61, Barnsley Road
Upper Cumberworth
Huddersfield
HD8 8NS

Application N° 2023/91280 Bromley Farm

HGV ROUTING PLAN

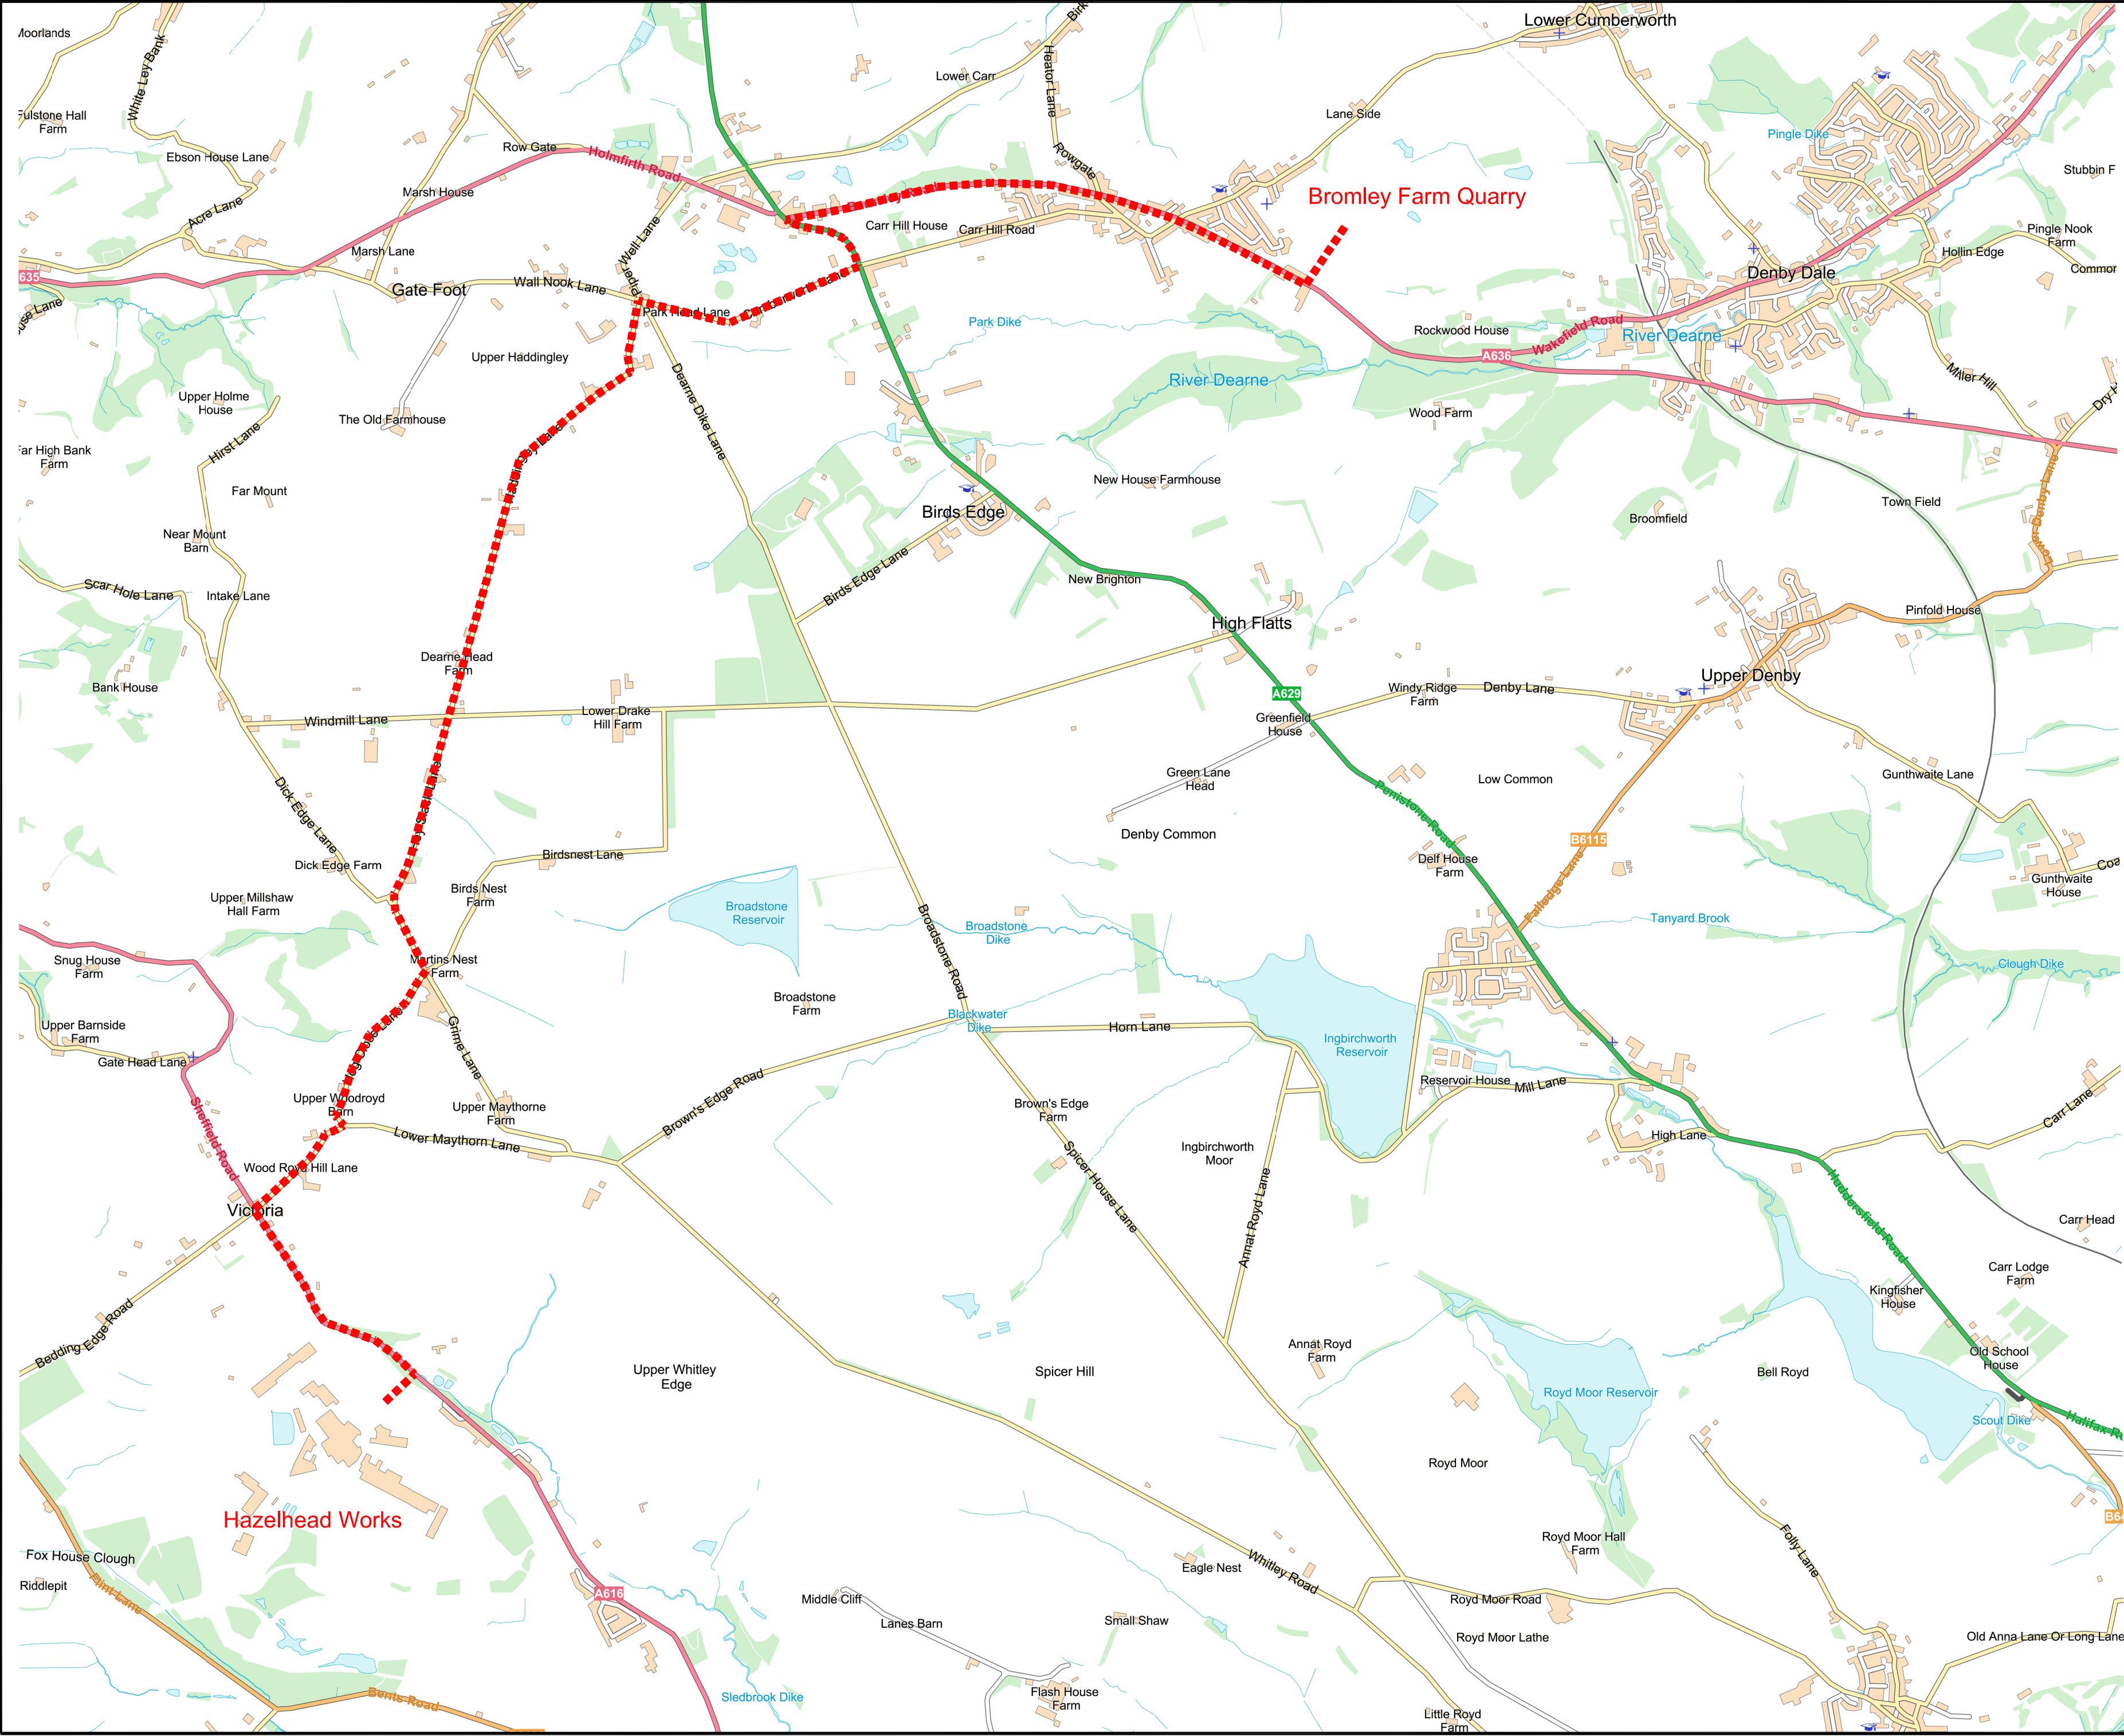
1. **The route the waggons take.** I deliver our community newsletter to Carr Hill Road and all the streets that are served by this. Between the Star and the junction of the A629 Carr Hill Road serves 94 properties either along its length or from side roads that must use it. As you well know there is no footpaths to most of the length of Carr Hill Road, which is regularly used by walkers, cyclists, horses, and many cars using it as a short cut to the A629. Heavy goods vehicles are allowed to travel up from the Star but not towards it. On numerous occasions the downward ban is ignored by HGV's. Three passed me coming down last week, two PMW waggons and one labelled Cartworth, all in the 15 minutes it took me to walk the length of the road. Mums and young children regularly walk up and down this road both to the school and the Post Office/store at the other side of Barnsley Road. This road is only wide enough for two cars to pass but this is often made difficult because of parked cars.

The obvious route for HGV's would be straight up from the quarry to the Sovereign crossroad. To turn right onto the A629 and immediate left onto the A635 and continue to New Mill. This section from the Star to the Sovereign has only thirteen houses on the right and seven on the left that have access to the main road. There is no problem in turning right at the Sovereign as this is a regular occurrence by PMW waggons coming from and returning to their depot on the New Mill Road together with numerous other large vehicles travelling towards Holmfirth or Huddersfield. This turn is also made by the three bus services that serve the local area. This route from the quarry all the way to New Mill has a footpath and the road is at least three vehicles wide for most of its length. On reaching New Mill a left turn onto the A616 Sheffield Road eventually passes the entrance to Wavin's works. Two main roads designed specifically for heavy usage so why route HGV's through what amounts to a residential area? To make this

route safer through Upper Cumberworth, I would suggest it is necessary to reduce the speed limit from 40mph to 30 mph, and make sure that the signage is visible.
